Thomas FitzGerald - Online Submission from Helen Wilson (object)

Major Project 09_0166

Altitude Aspire – Stages 1-11 Parish of Terranora, County of Rous

Objection to the Project

CUT & FILL SHADE PLAN

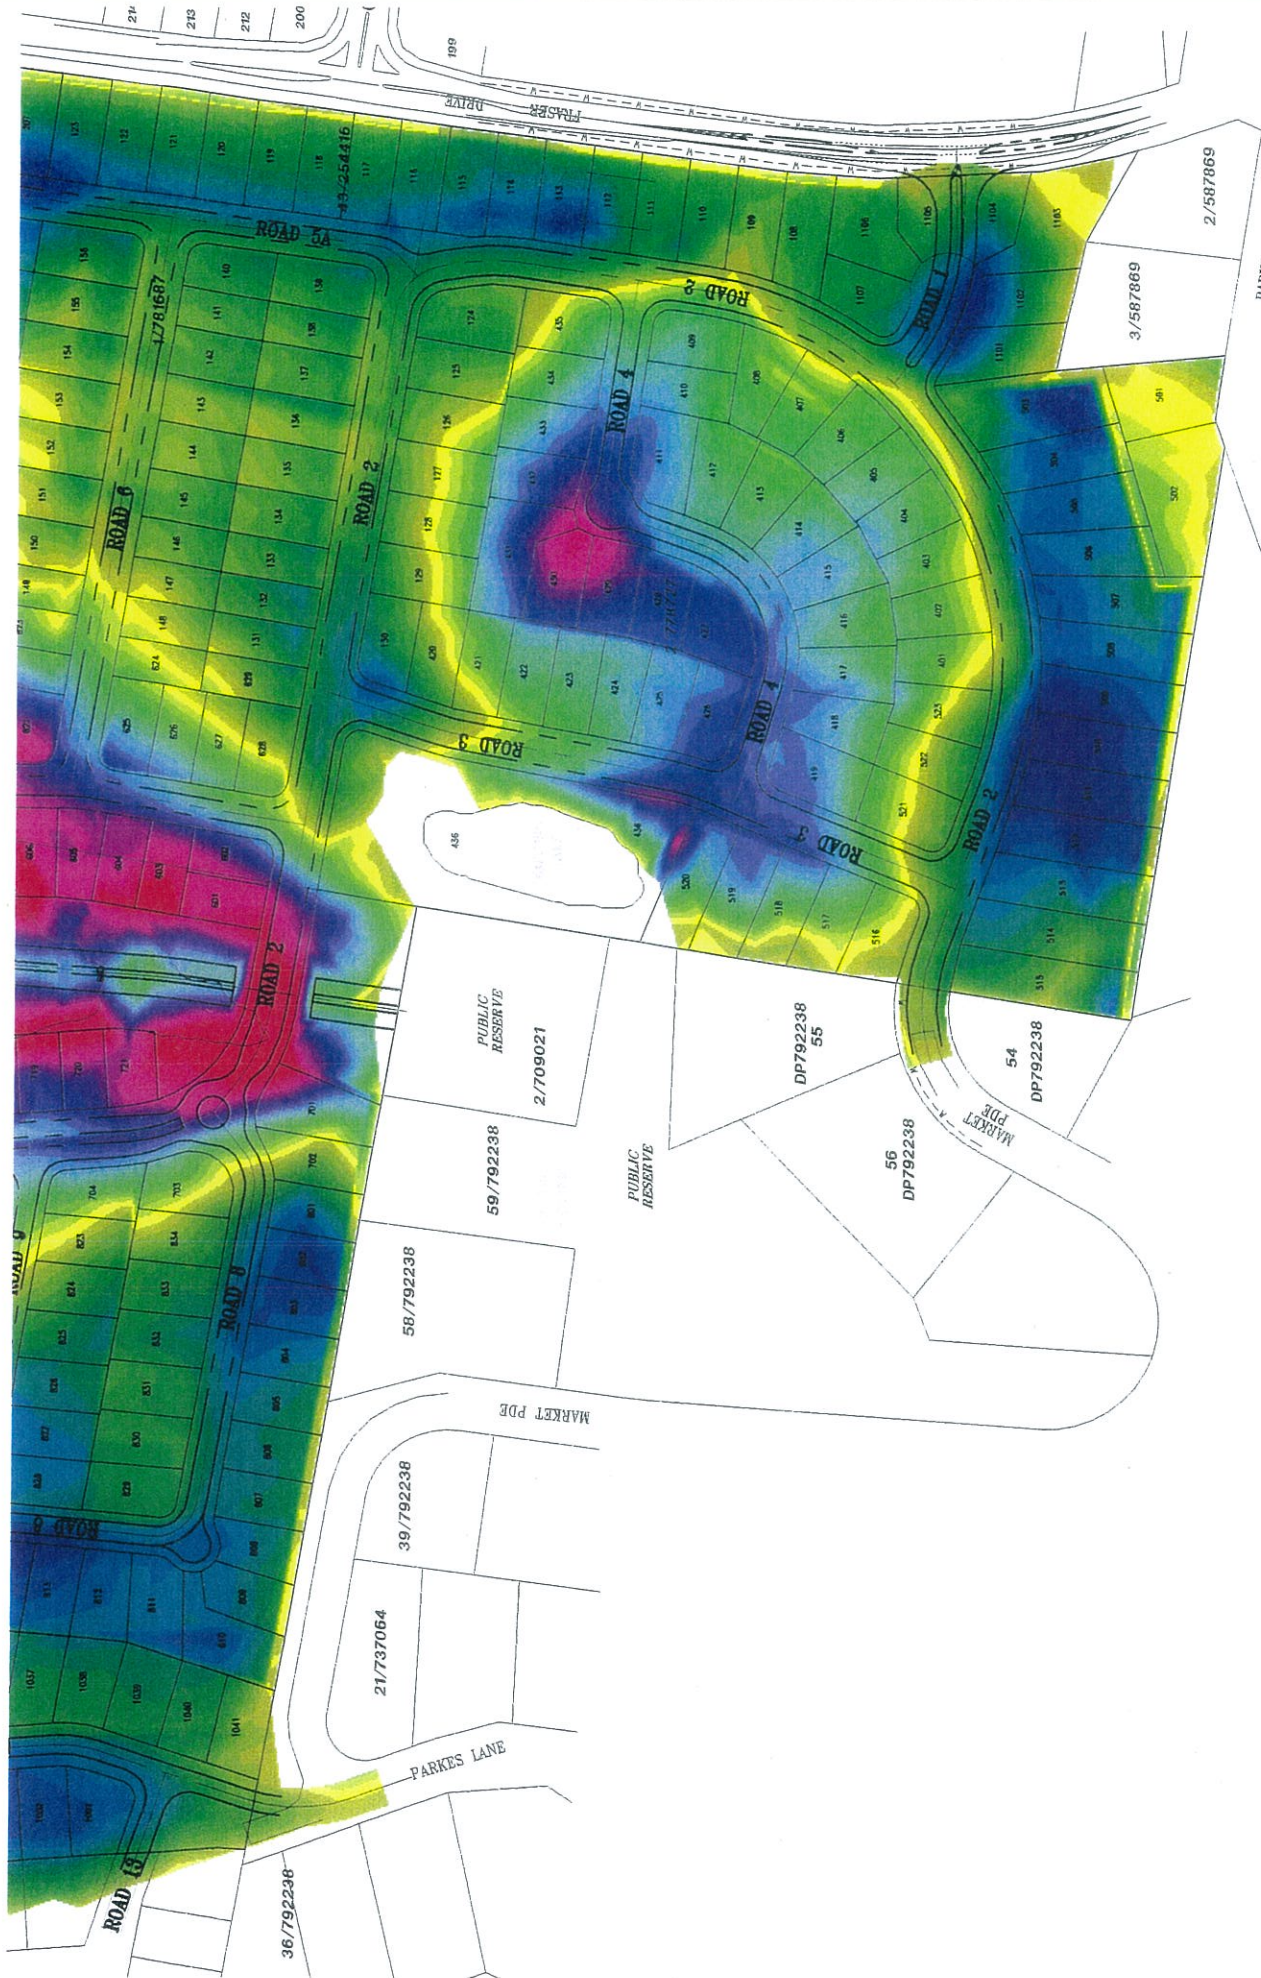
- The subdivision design does not comply with Tweed DCP 2008. The balanced earthworks across the site do not justify the significant inconsistency with Tweed DCP 2008. *Approx 18% of the site will require earth works at greater than 5m depth – Bradlees Civil Consulting, Nov 2010.* Tweed DCP 2008 restricts this figure to !0% and up to 15% where environmental benefit can be demonstrated. In this instance the balanced earths and avoidance of importing fill could not be countenanced as a demonstrated environmental benefit, as the objective is to generate the maximum yield of allotments, not to achieve a design sympathetic to the topography – some fill areas are up to 15m.
